Prior Notification for Permitted Development (Non Householder)

Development: Notification of Prior Approval under Schedule 2, Part 3, Class M of the Town & Country (General Permitted Development (England) Order (as amended) for the change of use from shop (A1) to residential (C3)
Location: 23a Felpham Road Felpham PO22 7DA

Drg. no. 2017/02x Sept. 2020
O'NEILL ARCHITECTURAL SERVICES
Tel: [01243] 531333

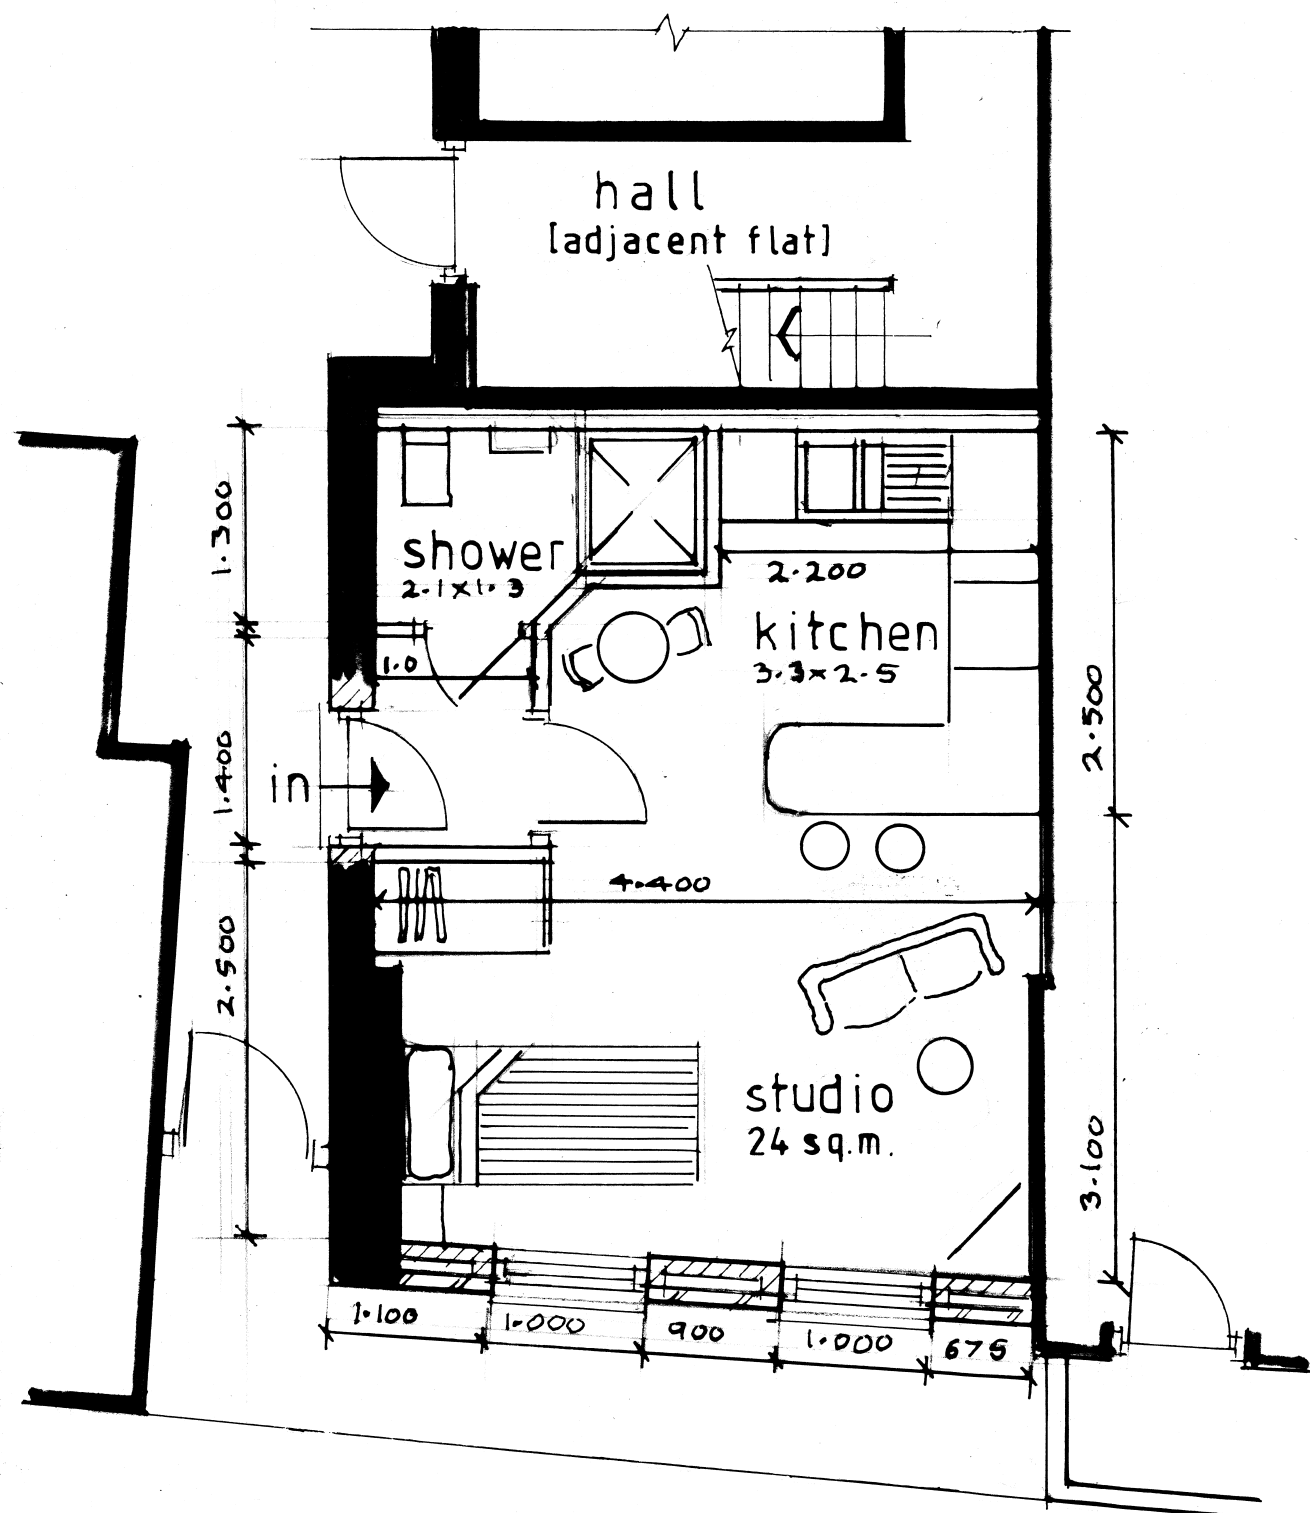
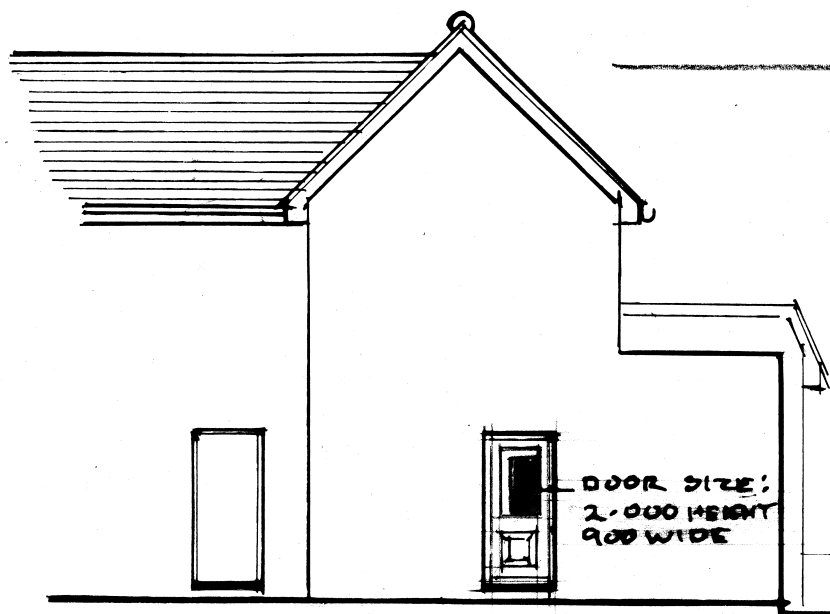
Floor Plans

As per the General Permitted Development Order Part W (bc) in relation to development under Class M,N,O,PA or Q, a floor plan indicating the dimensions & proposed use of each room, the position & dimensions of windows, doors and walls is required. Please amend the submitted floor plan accordingly to include the dimensions and re submit.
